City of Albuquerque Stormwater Construction Site Inspection Report

General Information					
ESC File No.	N15E017	Project Name:	Event Center on University		
NPDES Id. No.	NMR1006QG	Location:	1611 Airtech Ct SE		
12/1/2025	Owner	Contractor			
Operator	Sergio and Azucena Valles				
Contact name & title	Nolberto Trevizo				
e-mail	betto@lindomexicogrill.com				
Contact Phone #	505-288-4394				
COA Inspector	Chancellor English	Start/End Time:	11:30am		
Construction Phase:	Grading				
Type of Inspection:	Regular	Storm Event	Post Storm Event >0.25"	311/Complaint	Follow Up
Weather at time of inspection?	clear		Temperature: ~	45	
Estimated date of last storm 0.25" or greater	11/20/2025

PROJECT NO.	24001
DESIGNED BY:	RJF
DRAWN BY:	JB
CHECKED BY:	RJF
DATE:	JUNE 2024
SHEET TITLE	EROSION CONTROL PLAN
SHEET NO:	1 OF 2

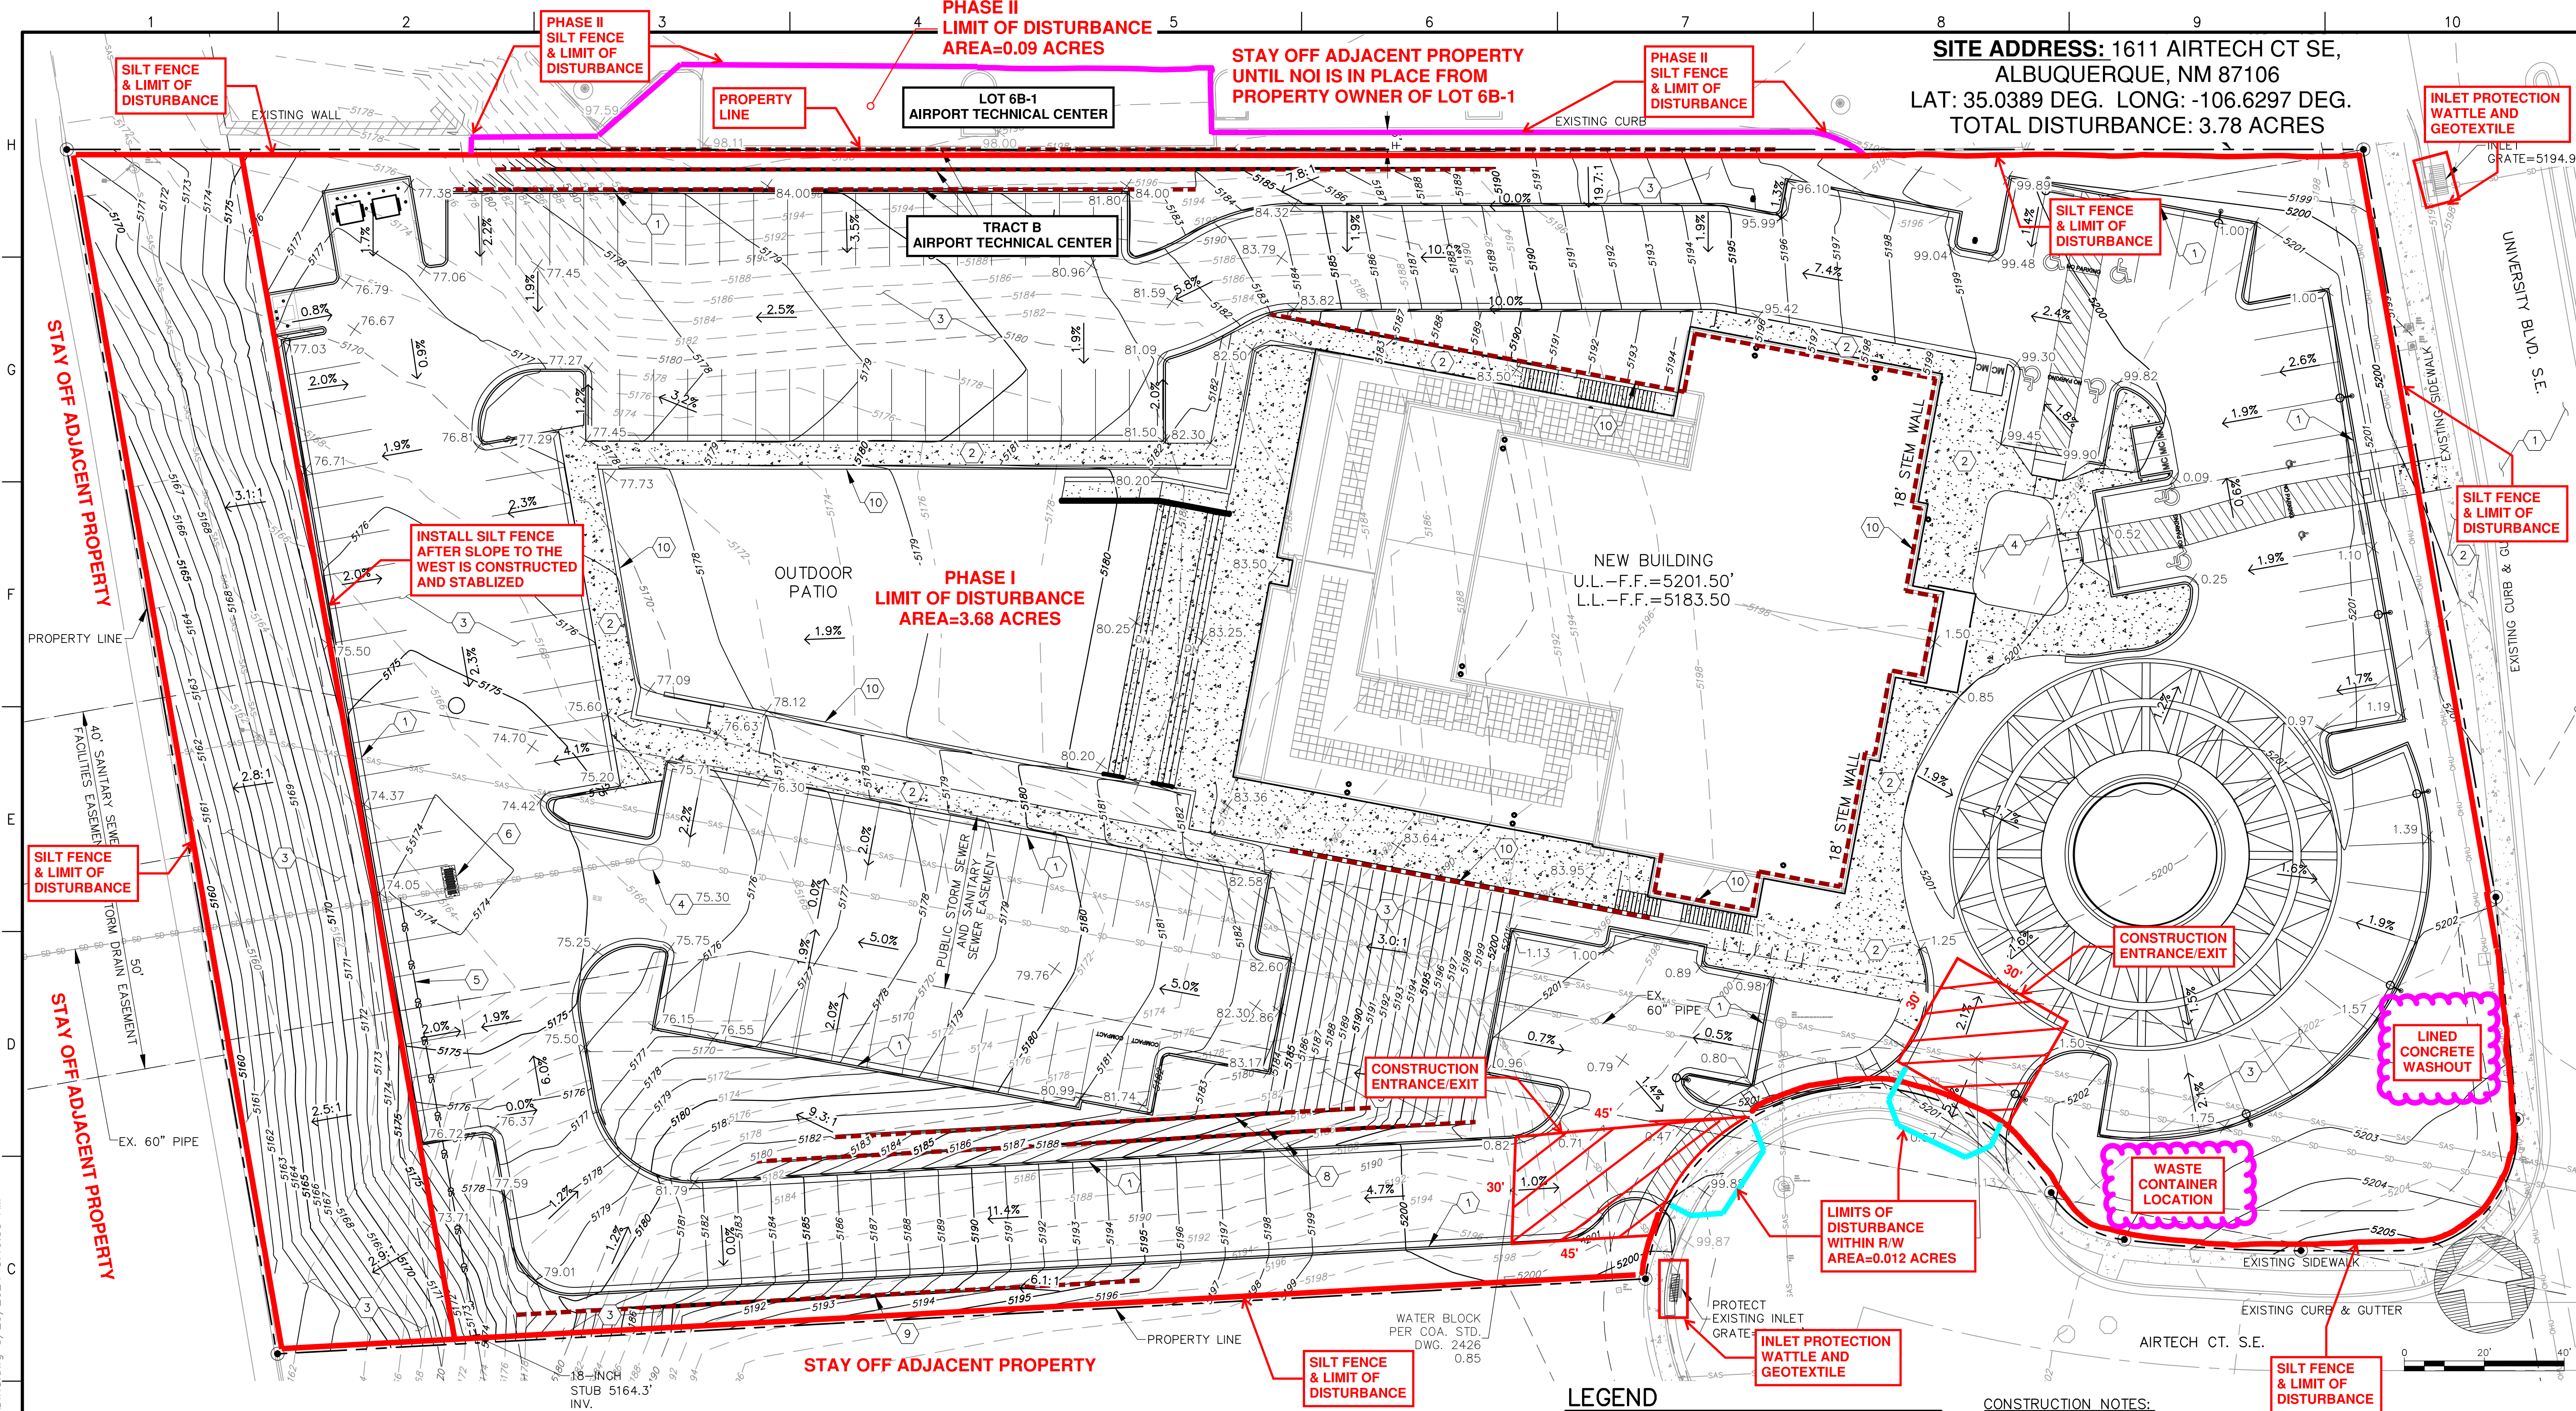
Item Number	Deficiency/ Corrective Action				
1	The SWPPP has not been certified by the operators in violation of CGP Part 7.2.10. There were no self-inspection reports available on-site in violation of CGP Part 4.7.3. Required mitigation: You must keep a copy of all inspection reports at the site or at an easily accessible location so that they can be made immediately available at the time of an on-site inspection per CGP Part 4.7.3.				
2	BMPs - Erosion on the west slope and property line has started undercutting the perimeter silt fence, which has discharged sediment onto the neighboring property in violation of CGP Parts 2.1.4 and 2.2.3. Required mitigation: Ensure all stormwater controls are maintained and remain in effective operating condition during permit coverage and are protected from activities that would reduce their effectiveness per CGP Part 2.1.4. After a storm event, if there is evidence of stormwater circumventing or undercutting the perimeter control, extend controls and/or repair undercut areas to fix the problem per CGP Part 2.2.3.c.ii.

Notes:	
Sediment from erosion is building up on the western silt fence and should be properly maintained. The SWPPP is in a lock-box (Code: 0000)	
The EPA requires temporary or permanent stabilization measures to be installed if land disturbances are in active for 14 or more calendar days per CGP Part 2.2.14.
